**A D V I C E**

2. The proposal site is 12.8 ha. The Applicants, Mr and Mrs Bell, seek to construct a large Georgian-style house within the Forest of Bowland AONB. The landscaping proposals are extensive and involve circa 1.4 ha of woodland planting, 1,120 m of new hedgerow planting and 1.2 ha of new species rich grassland margins. A biodiversity net gain of 609.2% is claimed. Construction will use traditional country house building materials and Passivhaus Plus is to be achieved. Much is made in the application documents of the support of TAG. However, given that the group is committed to the support of traditional and classical architecture, their support is not surprising. It says very little about whether the proposal satisfies Paragraph 80(e) of the NPPF. Indeed TAG, as noted in the Randall Thorp assessment of the 1/3/2022 para 2.12 make the fundamental error of starting from an assumption that the site is suitable in principle to accommodate the development without ever asking whether this AONB site actually requires conservation or enhancement.

**PLANNING APPLICATION REF:  
3/2021/1008: HODDER GRANGE**

LOCATION PLAN 1:1250 @ A1

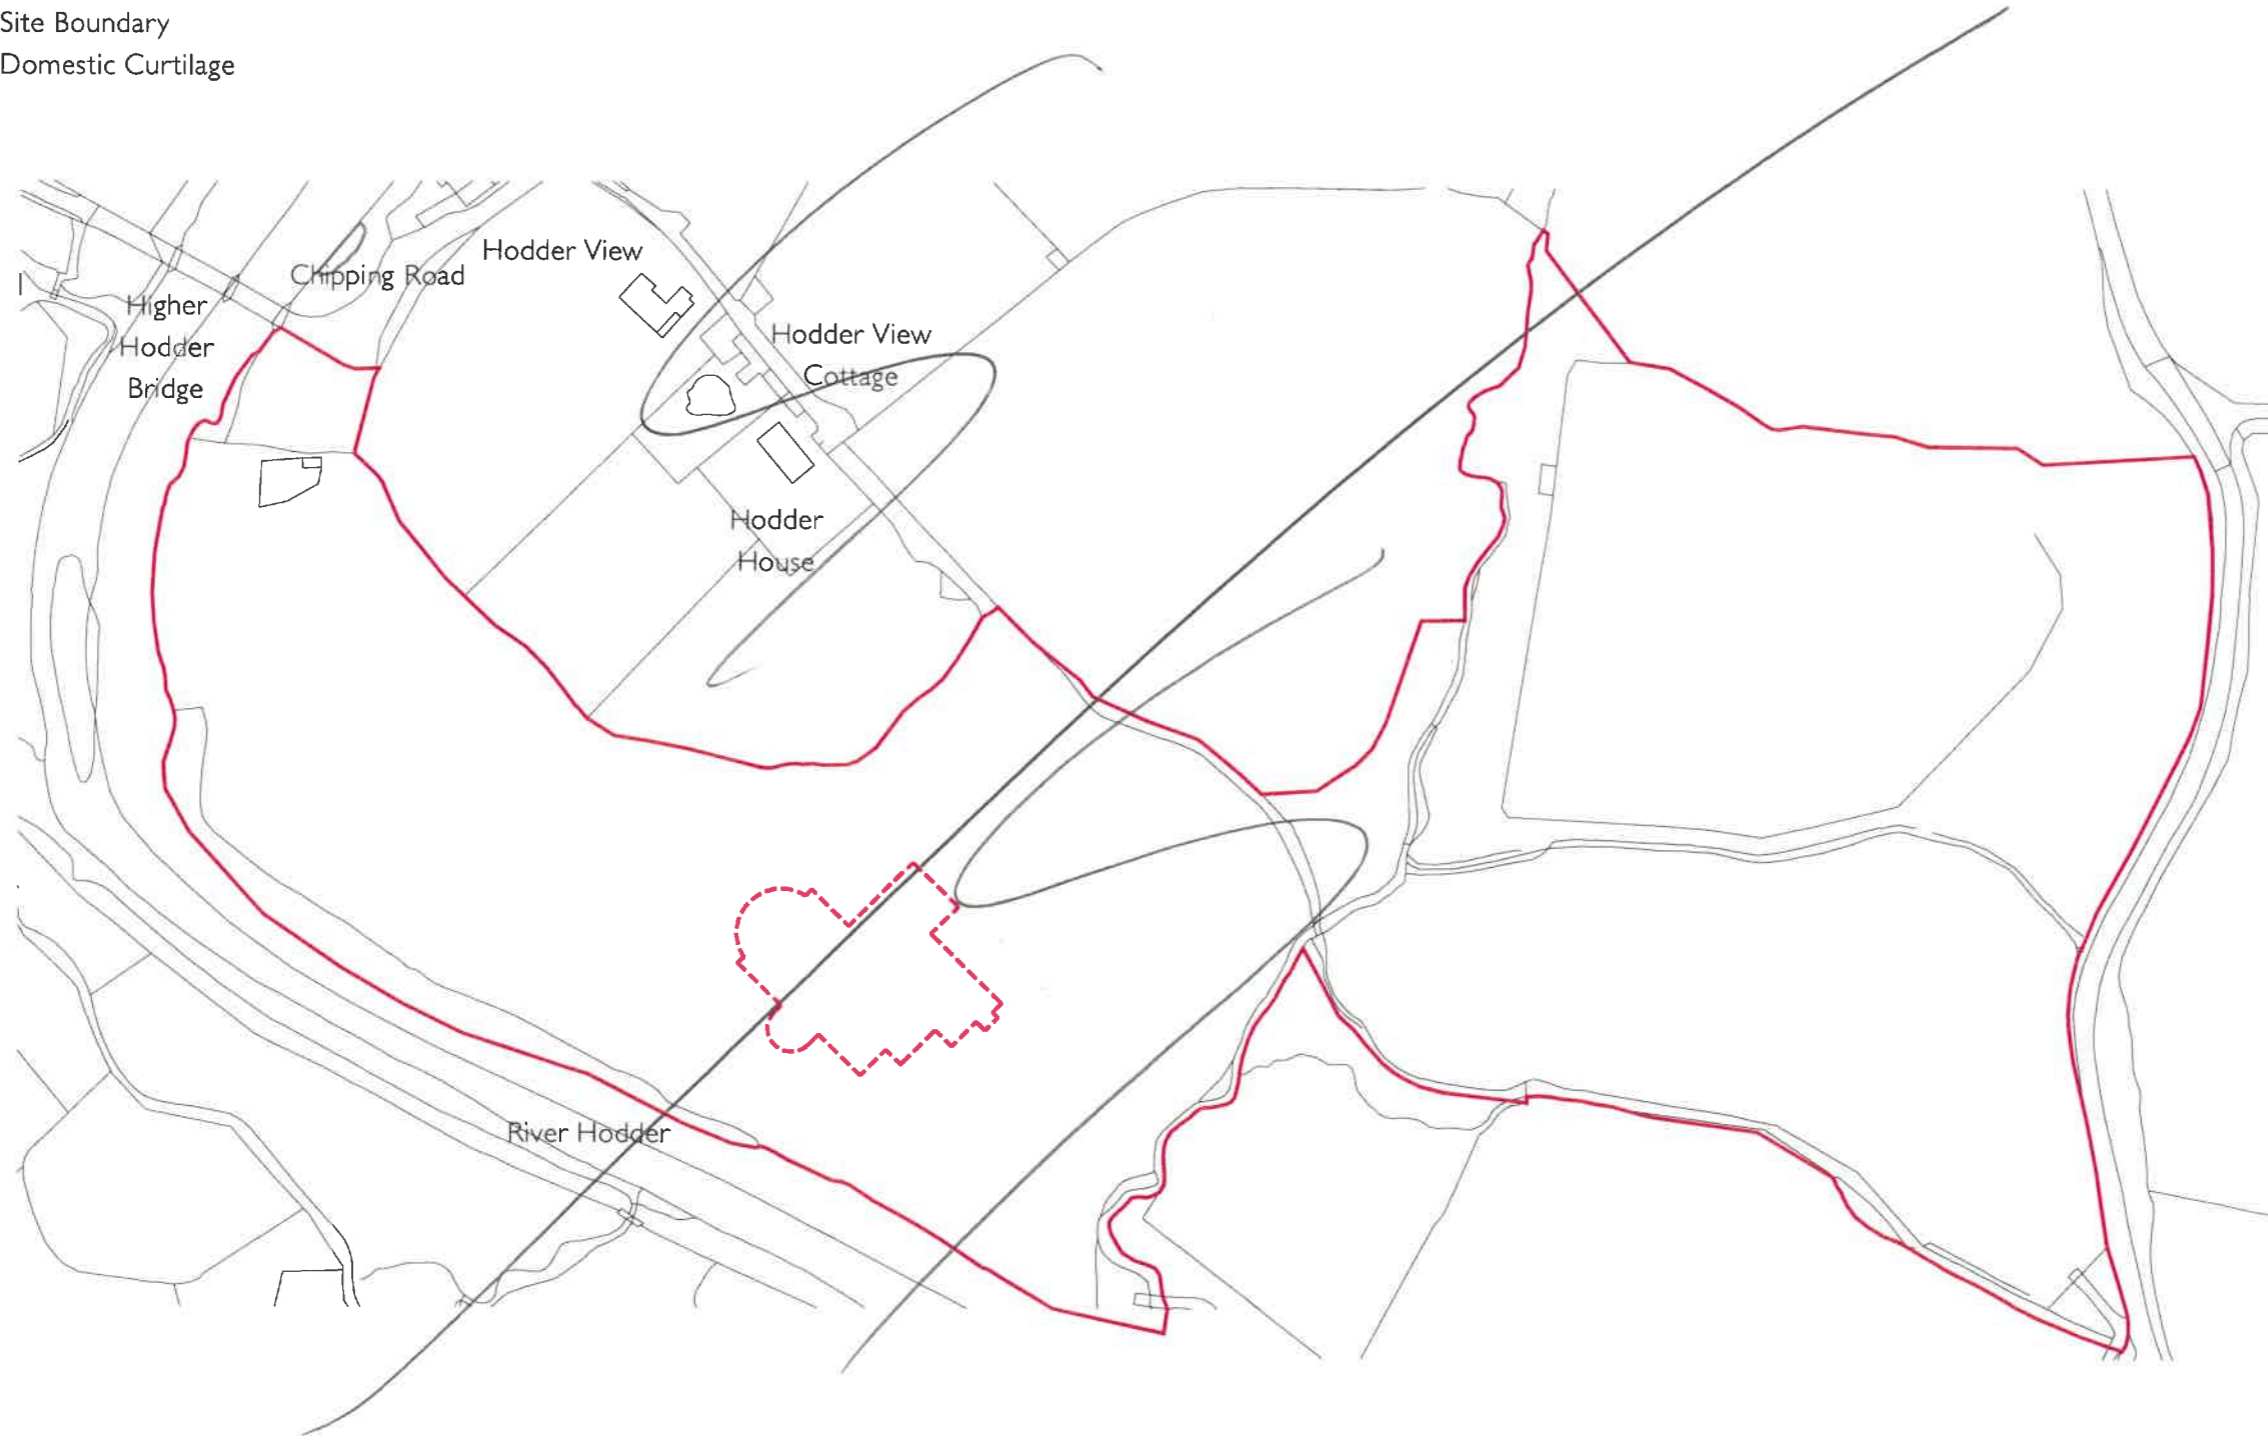
4. Before turning to the merits, or otherwise, of the application, I have some preliminary procedural observations.
5. Firstly, the “red line plan” accompanying the application appears to be narrowly drawn and does not embrace all of the land proposed for development. PPG advice in this regard is clear:

The application site should be edged clearly with a red line on the location plan. *It should include all land necessary to carry out the proposed development (eg land required for access to the site from a public highway, visibility spays, landscaping, car parking and open areas around buildings).* A blue line should be drawn around any other land owned by the applicant, close to or adjoining the application site.” (Emphasis supplied.)

If I have missed a correctly drawn location plan then I apologise, but if it is missing then the error requires remedy.
